Rezoning Transportation Analysis

Petition Number: 2020-150

General Location Identifier: Tax ID: 02508104

Date	Description
11-30-20	First Review (EL)
12-28-20	Second Review (EL)
1-21-21	Third Review (EL)

RZ1.0

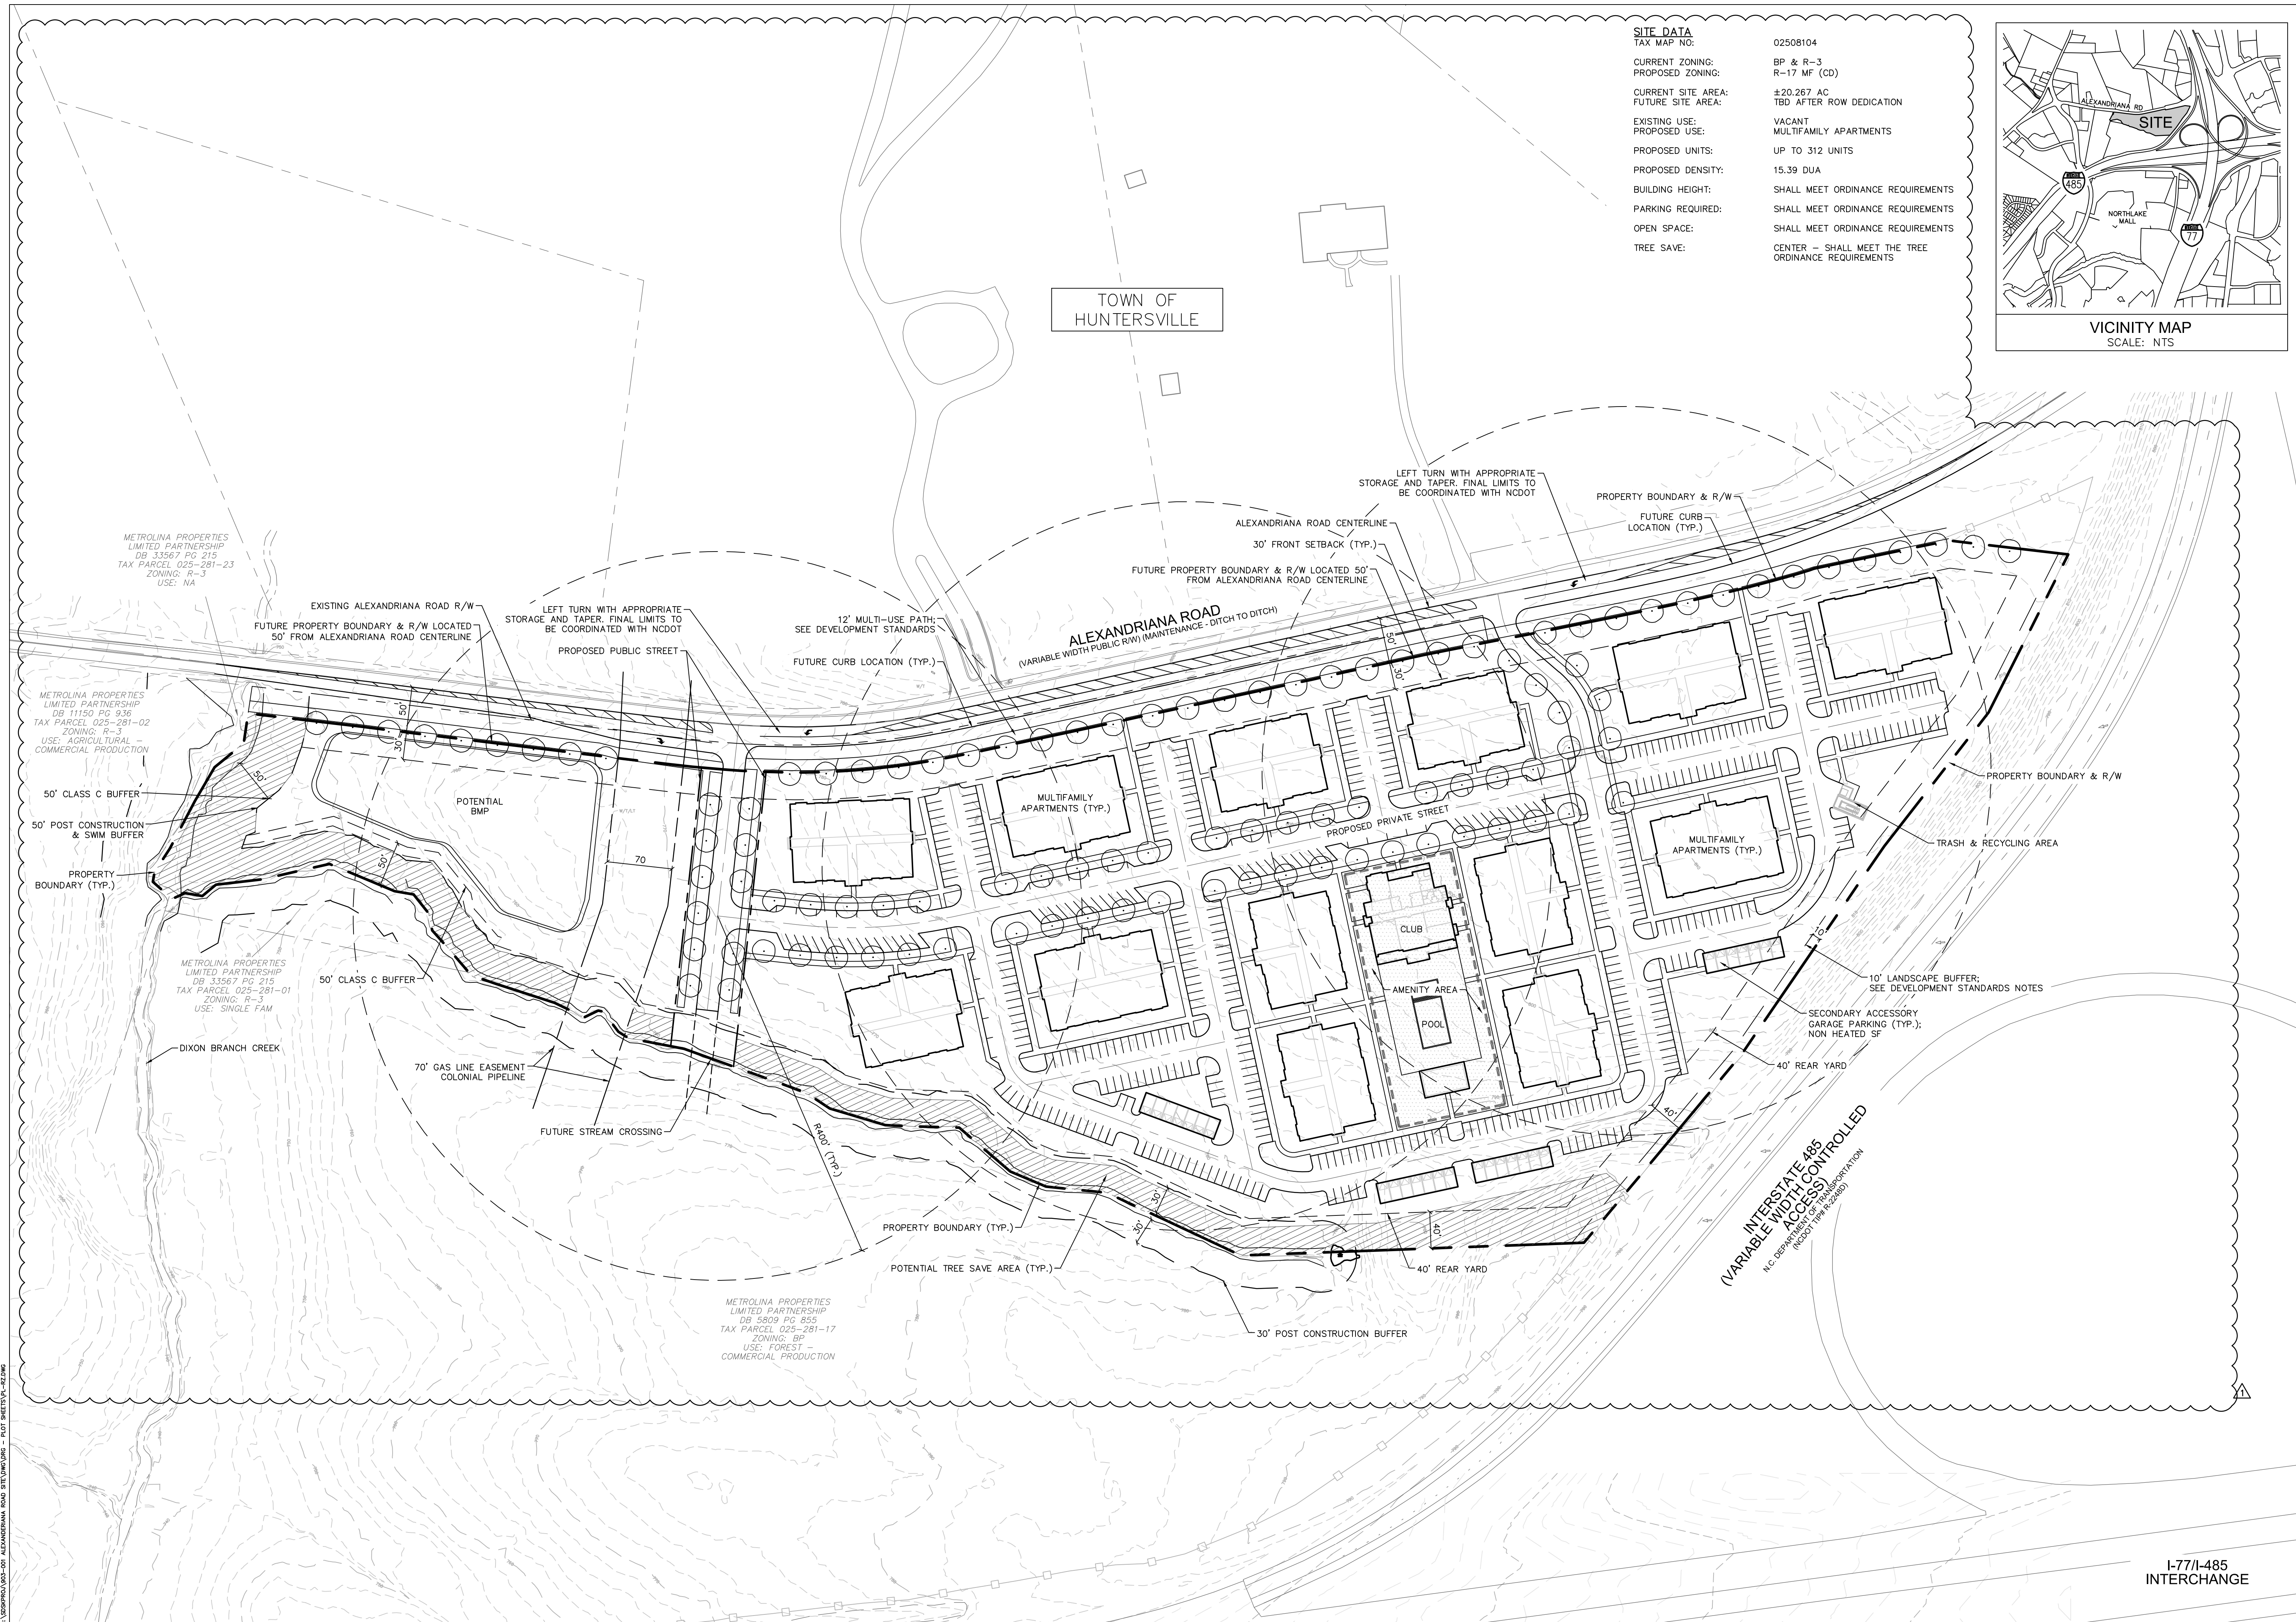
1. **Outstanding** (site plan dated 12.14.20) **Curbline:**

- a. **Alexandriana Road:** Location of curb and gutter needs to be installed at a location in coordination with NCDOT and CDOT. In reference to the North Lake Area Plan, the future cross section recommends a 4-lane divided facility with bike facilities. Coordinate with NCDOT (Stuart Basham) and CDOT to determine the right-of-way and asymmetric road widening needed for this future cross-section, while considering the following constraints: existing cemetery and Town of Huntersville jurisdiction limits to the north, future replacement/widening of Alexandriana Road bridge over I-77, etc. The total right-of-way width needed for this future cross section is 100-feet.

Label and dimension the curb and gutter from the centerline for each road on the site plan.

CDOT requests a 12-foot shared use path. The site plan shall label and dimension both items from the back of curb and gutter and road centerline.
